Demolition of existing dwelling & the erection of 7No. residential dwellings, with associated parking, amended access location from Lime Tree Close & landscaping.
Scorton 9 Lime Tree Close East Preston

Objection to Planning Application Ref EP5218PL 9 Lime Tree Close

TITLE: Swept Paths March 2018 SITE: Limetree Close East Preston	Drawing: Vehicle Swept Paths	Autoturn Vehicle Swept Path Analysis & Visibility Data Prepared by Autoturn Specialists in Simulated Vehicle Swept Paths
	Drawing Reference: LT.SWEPT.001	
	Scale: On A2 1:200 / as bar

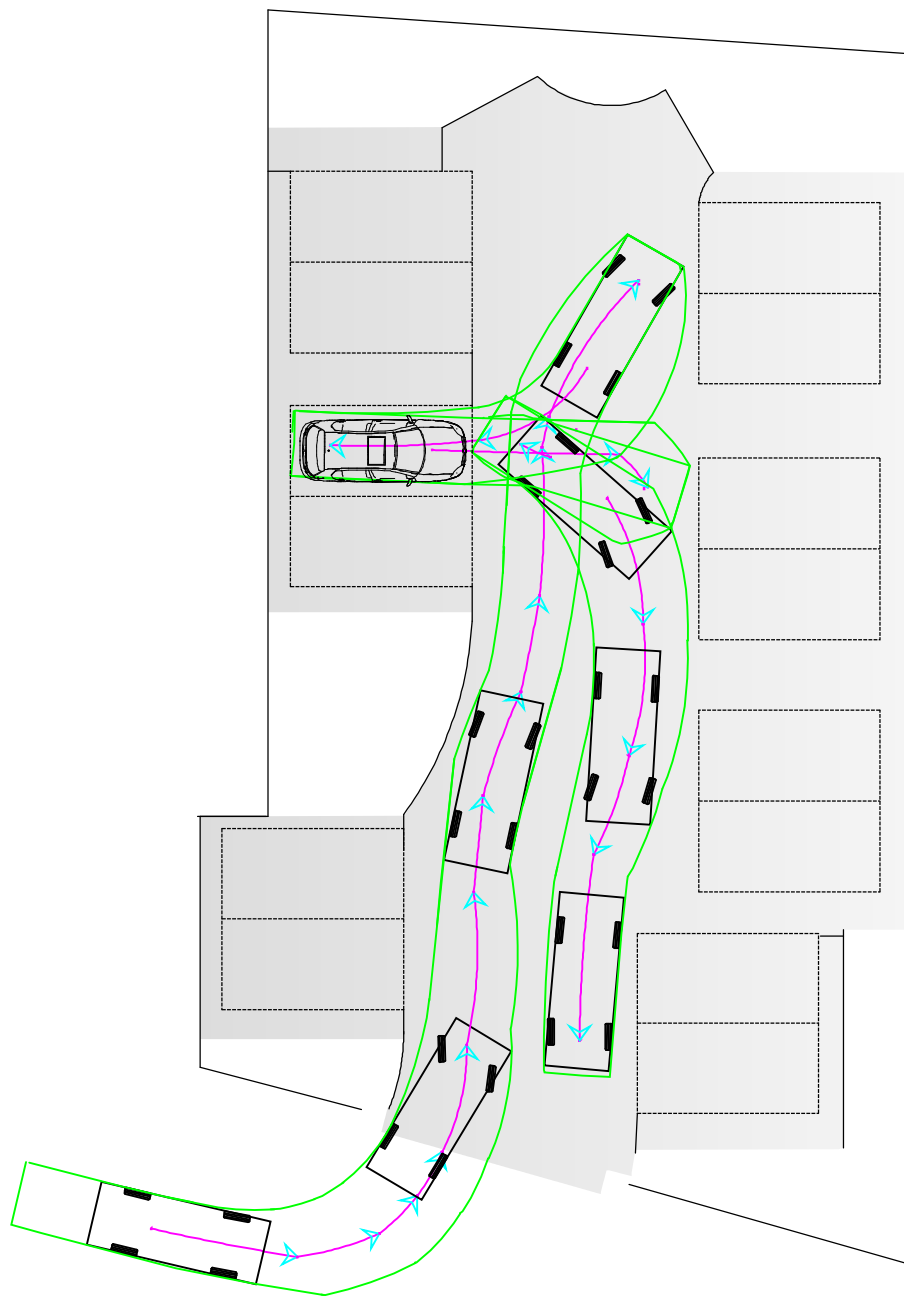
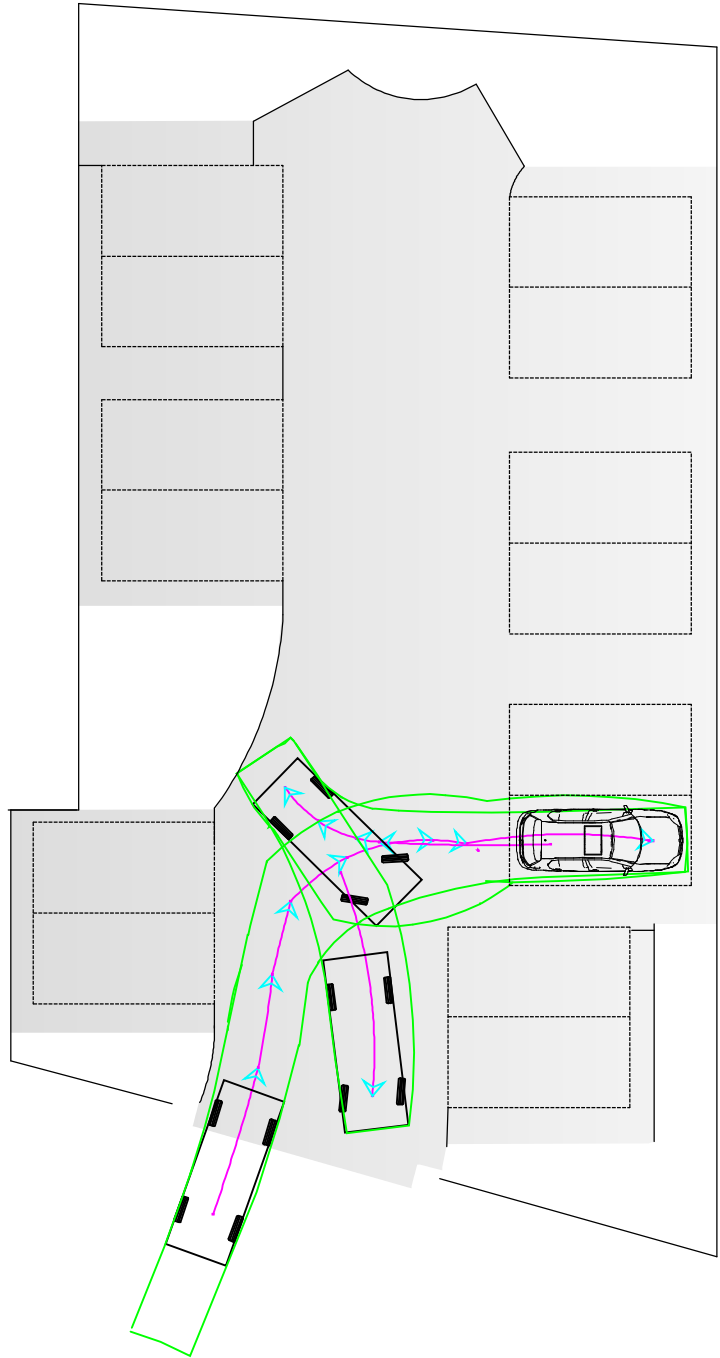
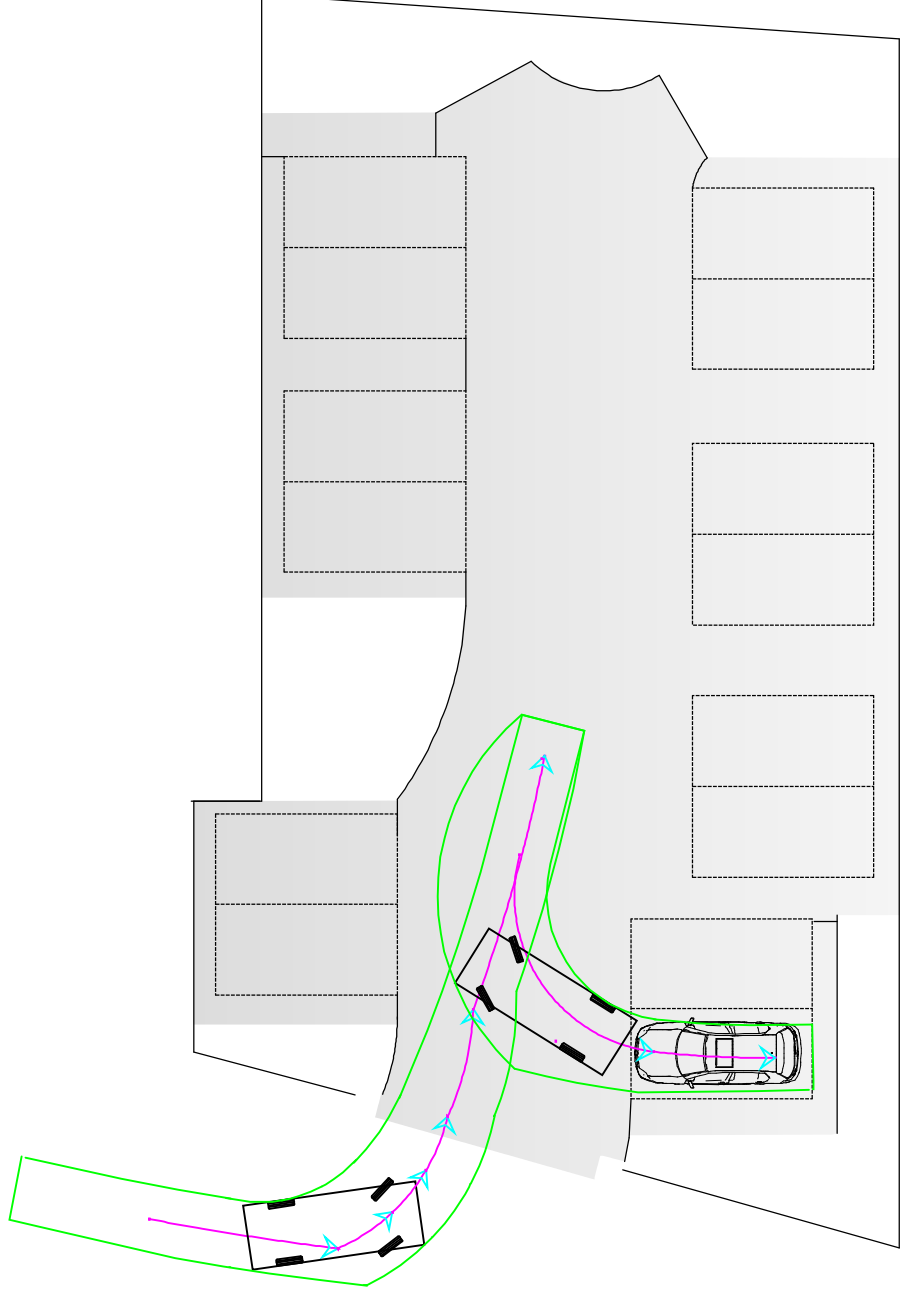
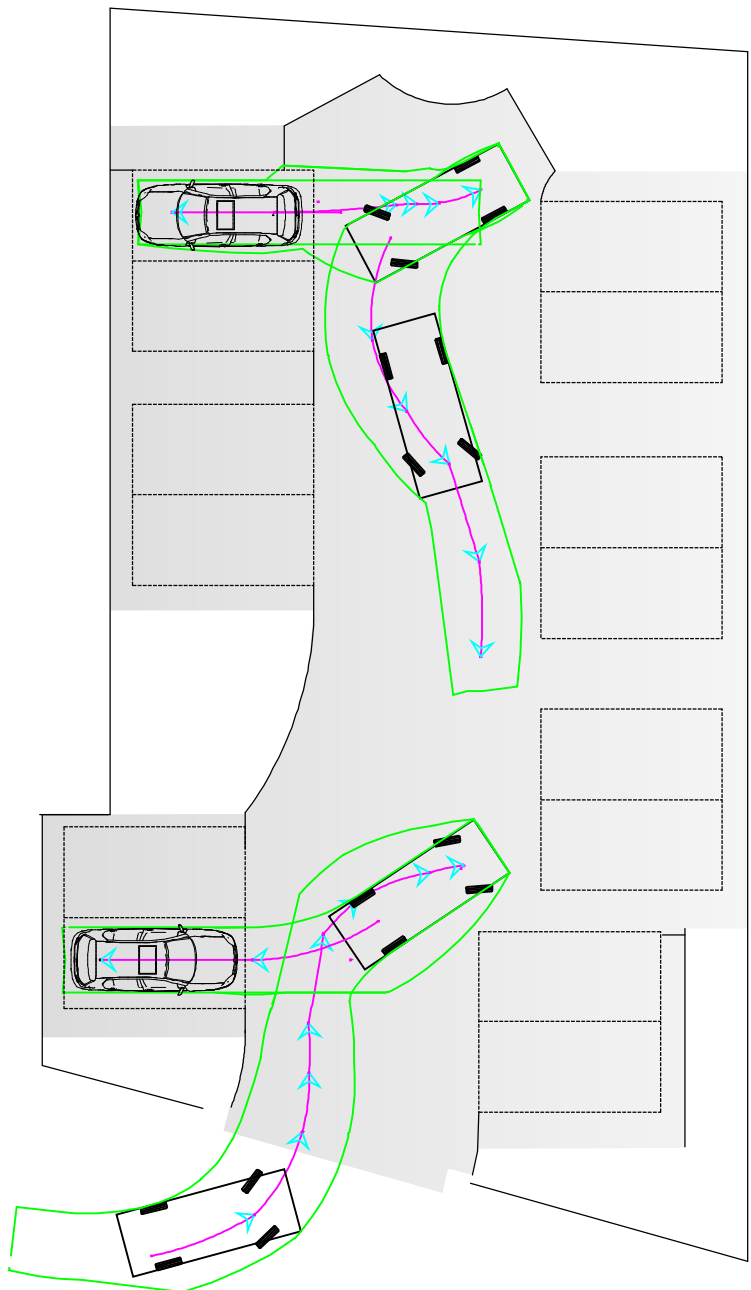
Lime Tree Close (LTC) is too narrow for easy access for the 14 vehicles on the site plan (Drawing Ref: LT.SL.004) as currently the south side of LTC is filled with parked cars. Manoeuvring in, out, and turning round will be hazardous.
